**Planning Application No: 3/2023/0750**

**Proposal: Creation of new french doors to rear elevation and conversion of garage to home office incorporating bi-fold doors.**

**Location: Abbey House West Lane Worston Clitheroe BB7 1QA**

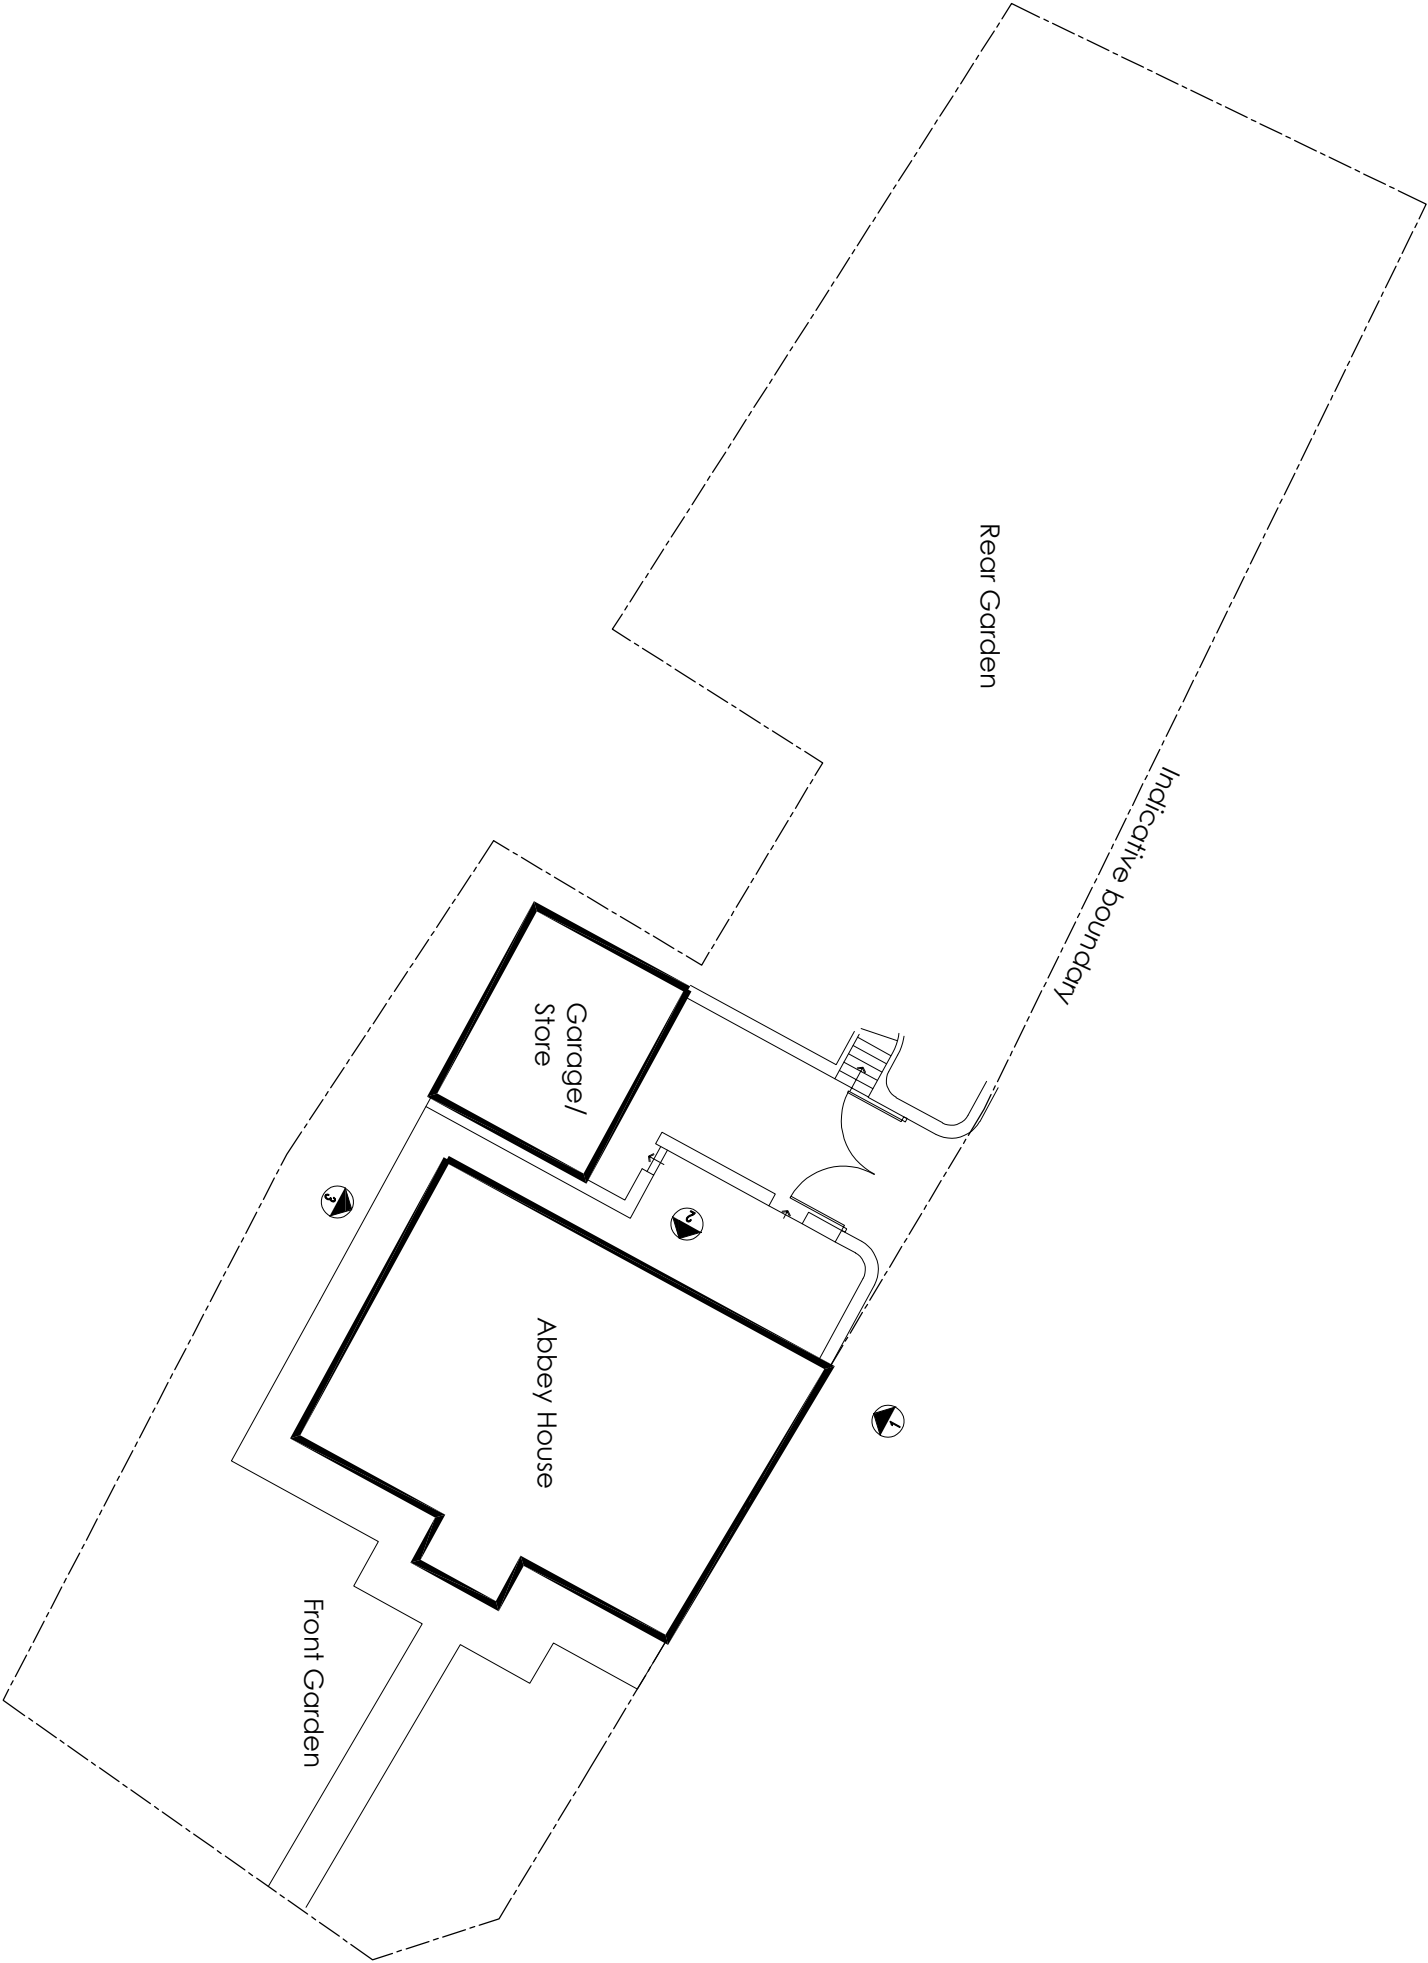
For the dwelling to comply with the parking standards as defined in the Joint Lancashire Structure Plan, the LHA require 3 car parking spaces to be provided on site.

However, even with the existing garage which will be converted following the proposal, only one car parking space can be provided on site on the driveway. Therefore, with the shortfall in parking being a pre-existing situation the LHA have no objection to the proposal.
